RE: **McDonald's - Old Town MRP**

File # **J13/D053**

Grading & Drainage Plan for Grading /Building Permit **PE Stamp: 1/27/14**

Based upon the information provided in your submittal received 1/28/2014, the above referenced plan cannot be approved for **Building Permit**. The following issues need to be addressed on this Grading and Drainage plan:

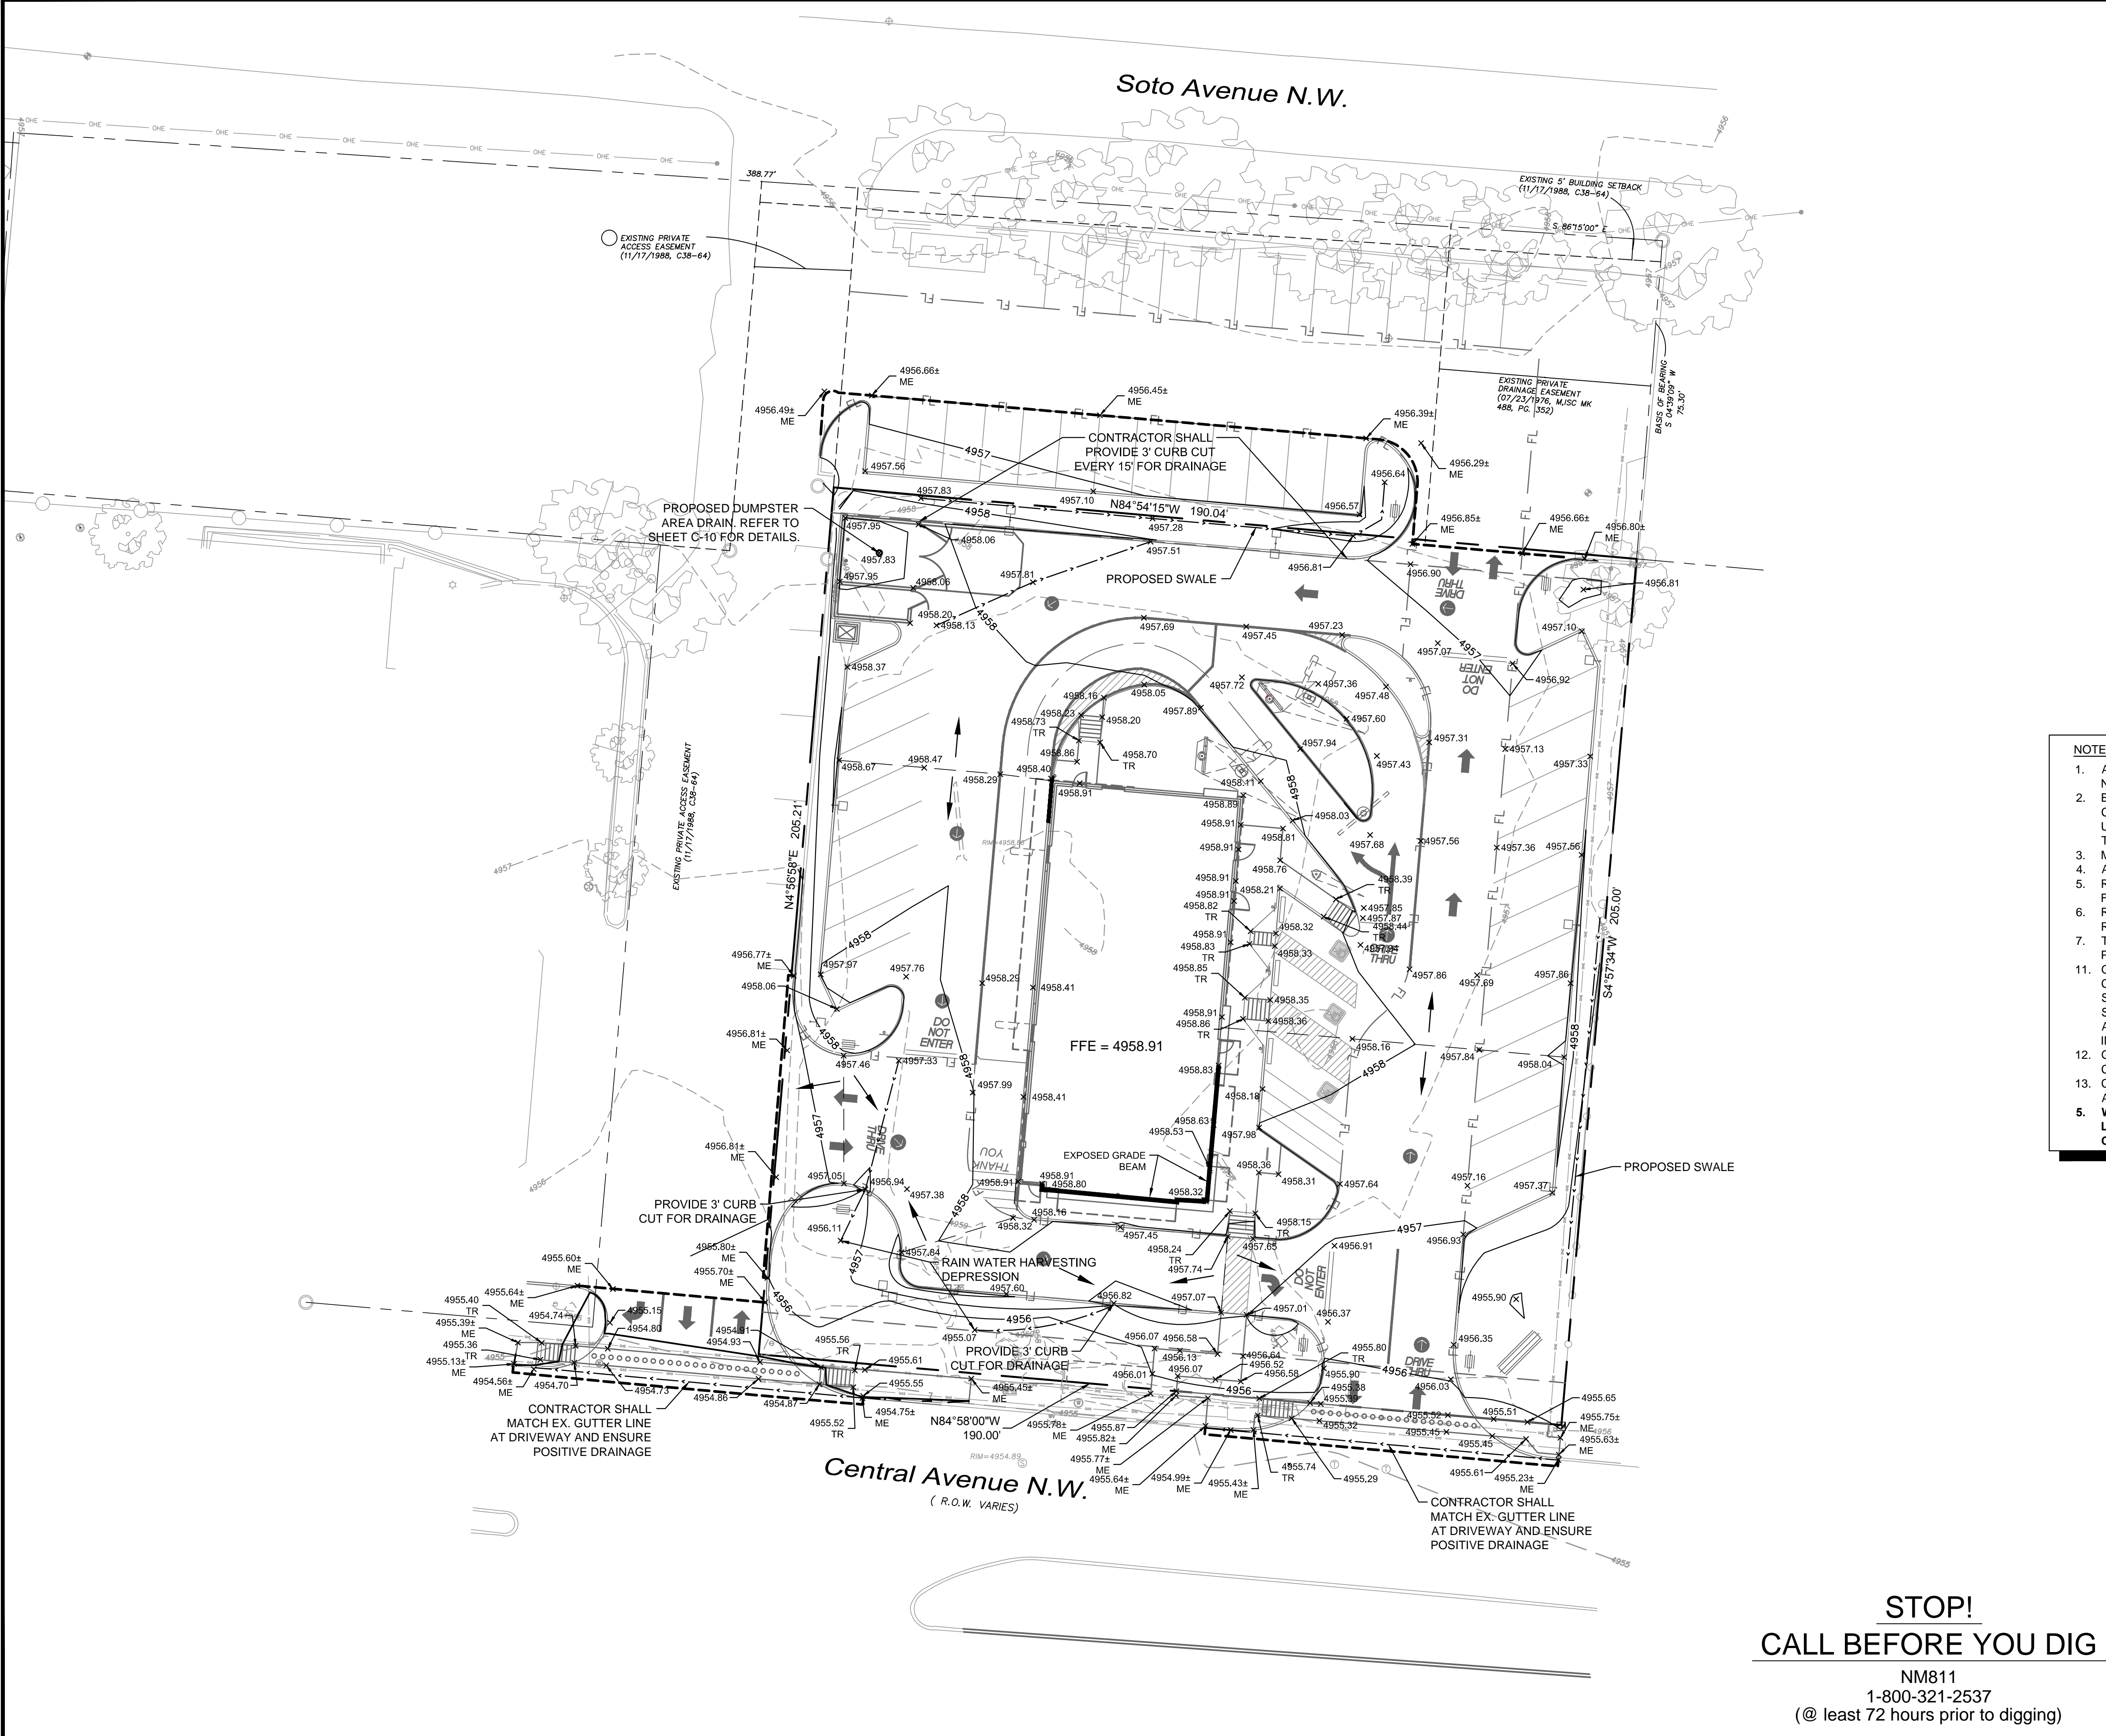
1. The drive entrance off Central Avenue needs to provide a water block to prevent "public storm water" from backing onto private property. City standards call for curb height, plus 2% slope to the R/W, which in this case (6' sidewalk) would a grade at the property of 0.79' above the gutter flow-line elevation.

2. The second note "5" on the Grading Plan (C-7) directs the contractor to depress landscaping "WHERE GRADES PERMIT" to provide for water harvesting. Your plan should provide the direction on the plan, with build notes and spot elevations, etc., to specify where depressions are to be provided. Note that the existing site landscaping has very definite depressed areas.

3. There are two existing drain pipes from the site to the curb on Central, which are not shown to be reused on this plan. You should call for them to be capped or removed to avoid erosion or settlement on the abandoned end within the site.
